From: Shirley Bridge [spbridge@hotmail.com]
Sent: 26 July 2012 12:29
To: planning
Subject: Planning Application No 3/2012/0578 READ PARISH COUNCIL
Planning Application No 3/2012/0578

Proposal: Development of outdoor adventure centre

Site Layout

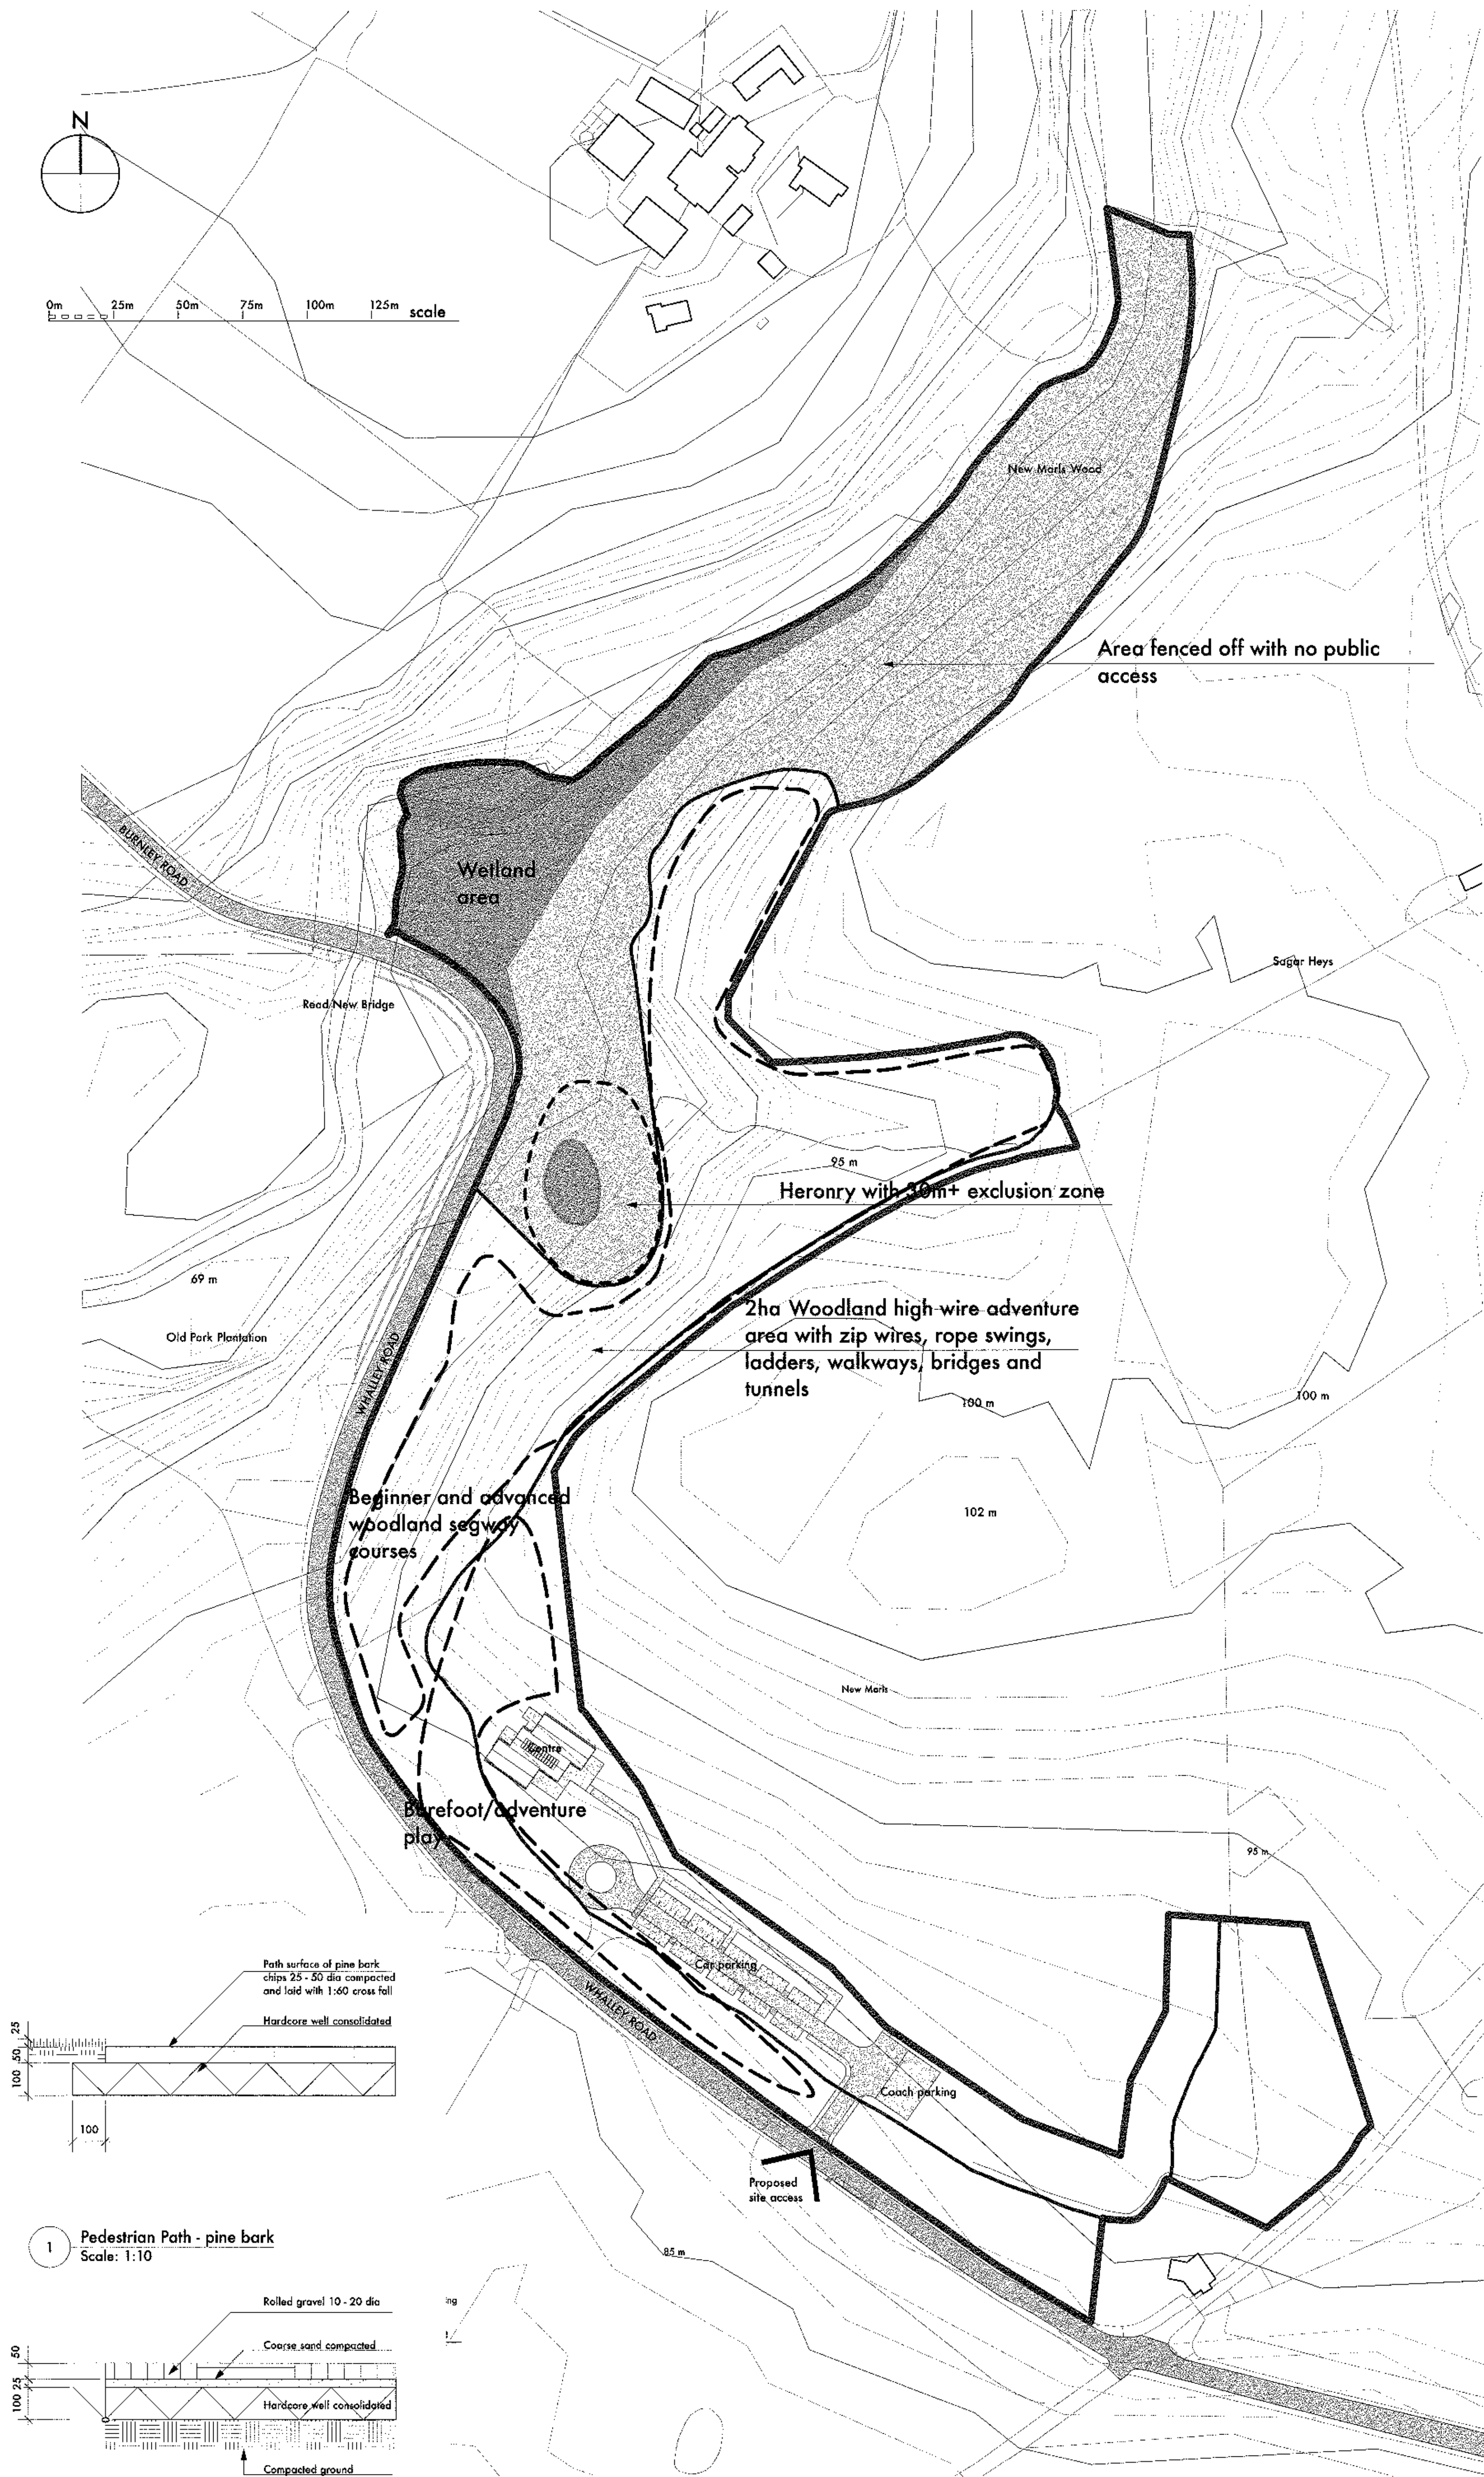
One comment is regarding the size of the proposed septic tank – are there assurances that this will be sufficient for the needs of a successful business with lots of visitors?
